Our Ref: 23/0886/TTCA  
Your Ref: HFH 20 Chishill Road Heydon

**South Cambridgeshire District Council**  
**Application for Works to Trees in a Conservation Area**

Site address: 20 Chishill Road Heydon Cambridgeshire SG8 8PW

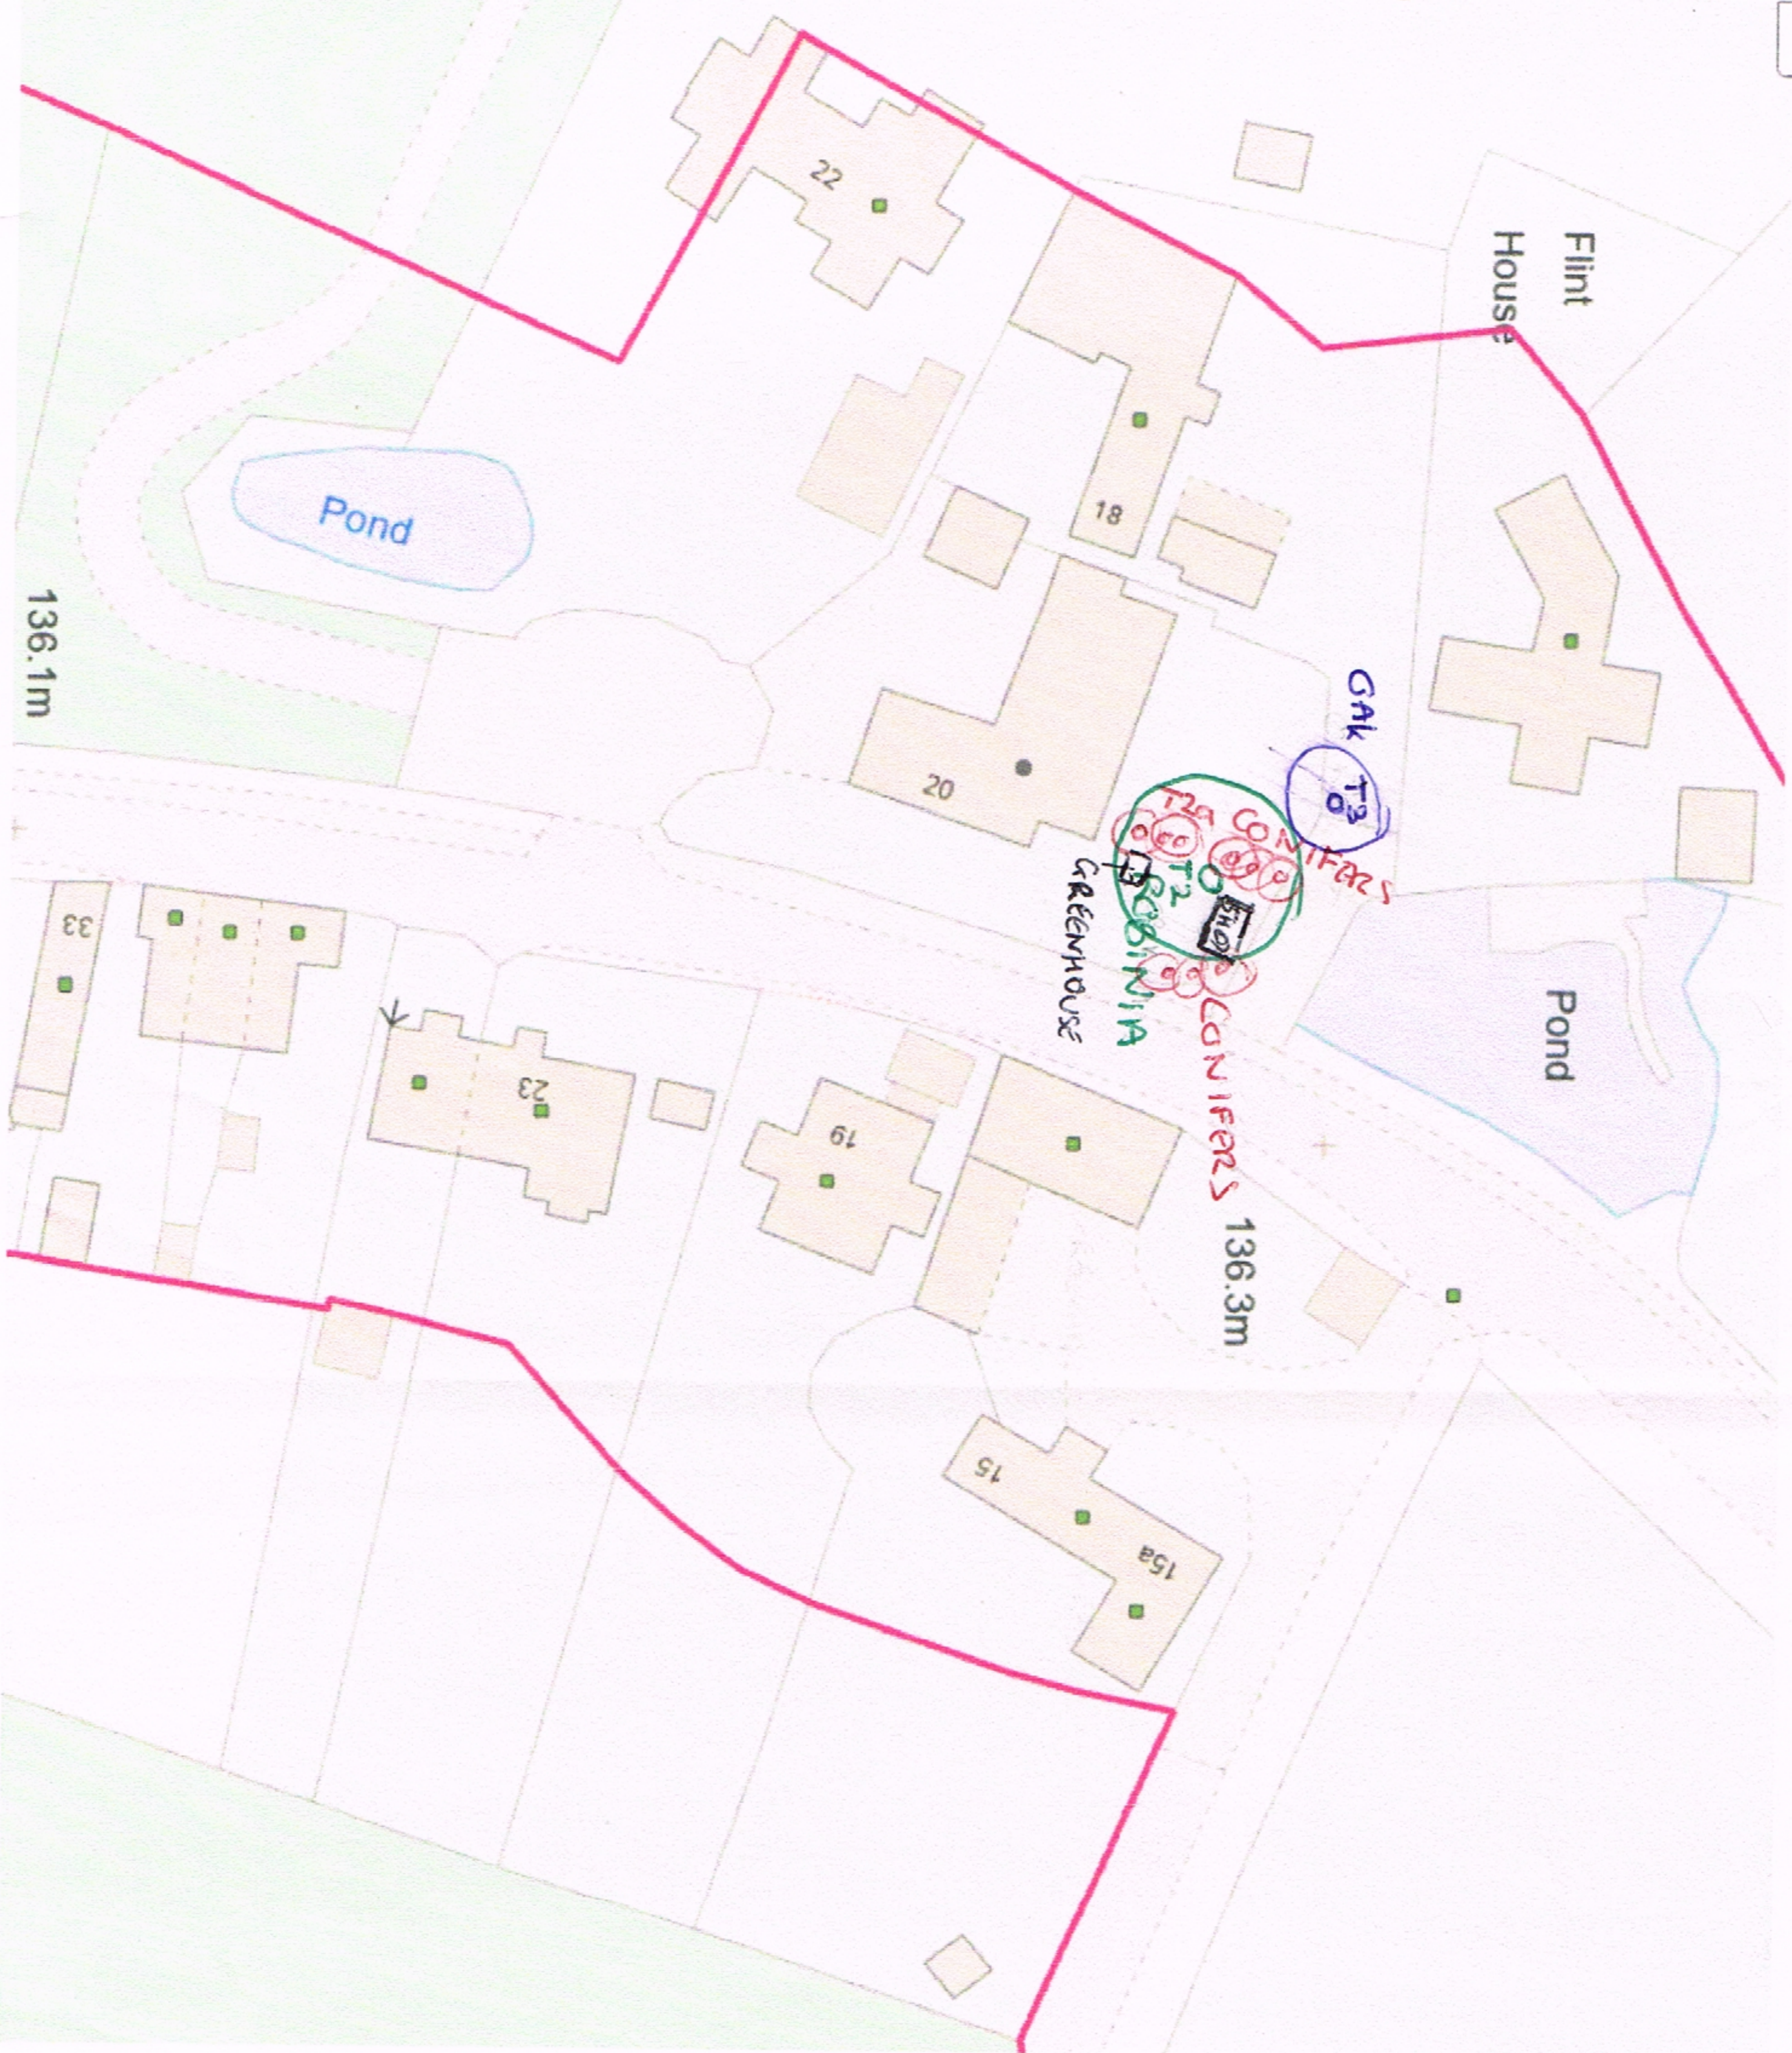
0. Does not appear to clearly identify or specify all the tree works. With regard to item T2a on your application 4 x conifers it is difficult to decipher which trees require the work based on the information provided. In addition your proposal does not indicate the extent of work required on the conifers - please state in metres the reduction or

clearance required.

We are forwarding a new plan for you to plot all the trees which require work, the present plan is unclear.

Your proposal refers to the location of T3 in the driveway of 18 - please confirm ownership of T3 ie on whose land does the trunk stand?

In addition 3 other conifers are mentioned which appear from your plan to require work, again, are these in your ownership? and what is the extent of work required?
